DEVIATION REQUEST AND DECISION FORM

Project Name : The Markets at Bent Grass
Schedule No.(s) : TBD
Legal Description : TBD

**RE: The Markets at Bent Grass Development
Conceptual Access Spacing Deviation Request**

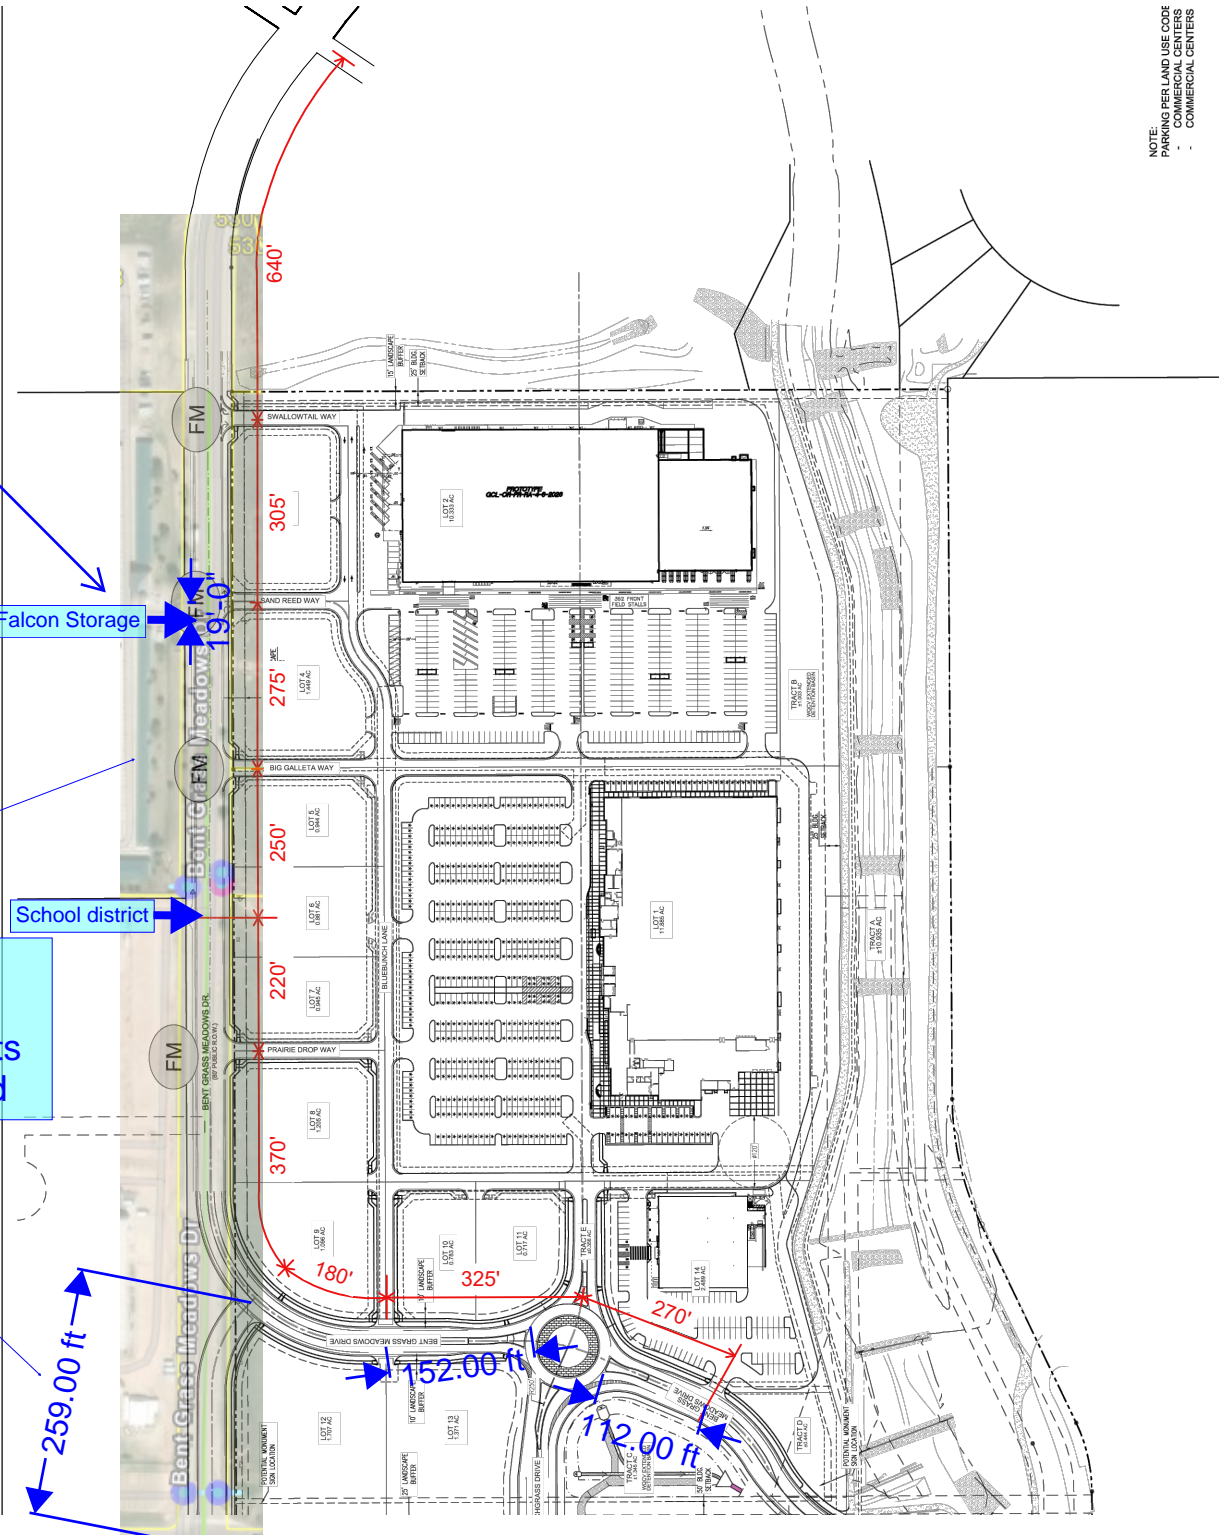
Dimension distances to this access
